City of Portland, Maine – Building or Use Permit Application 389 Congress Street, 04101, Tel: (207) 874-8703, FAX: 874-8716

BUILDING PERMIT REPORT

DATE: 12 Aug 97 ADDRESS: 27 Central Ave. PT.
 REASON FOR PERMIT: To rebuild porch.
 BUILDING OWNER: Goodell
 CONTRACTOR: owner
 PERMIT APPLICANT: ↑ APPROVAL: *1 *2 *8 *10 *21 DEFERRED
A26 *29

REBUILD AND ENHANCE REAR PORCH, 27 CENTRAL AVE
PEAKS ISLAND, ME

REBUILD AND ENHANCE REAR PORCH, 27 CENTRAL AVE  
PEAKS ISLAND, ME

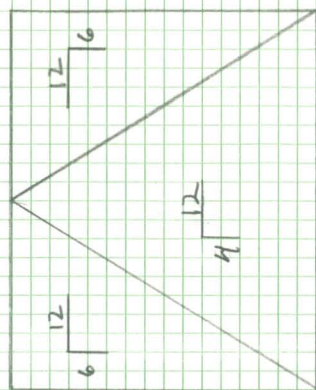
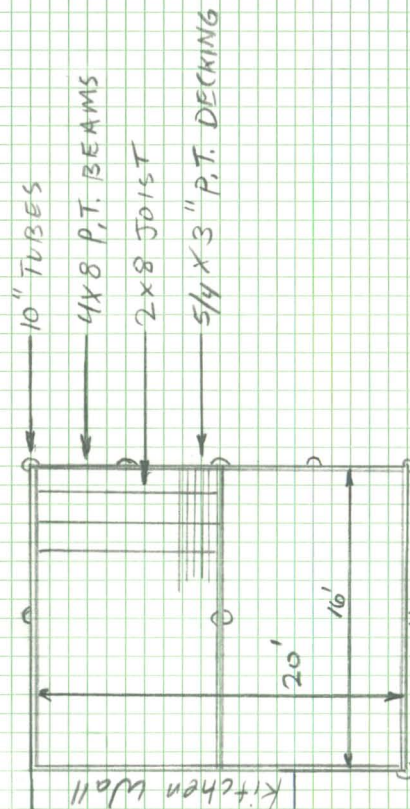
1. During its existence, all aspects of the Home Occupation criteria, Section 14-410, shall be maintained.
2. The footprint of the existing porch shall not be increased during maintenance reconstruction.

3. All the conditions placed on the original, previously approved, permit issued on _____ are still in effect for this amendment.
4. Your present structure is legally nonconforming as to ~~rear~~ side setbacks. If you were to demolish the building on your own volition, you will not be able to maintain these same setbacks. Instead you would need to meet the zoning setbacks set forth in today's ordinances. In order to preserve these legally non-conforming setbacks, you may only rebuild the ~~porch~~ porch in place and in phases.
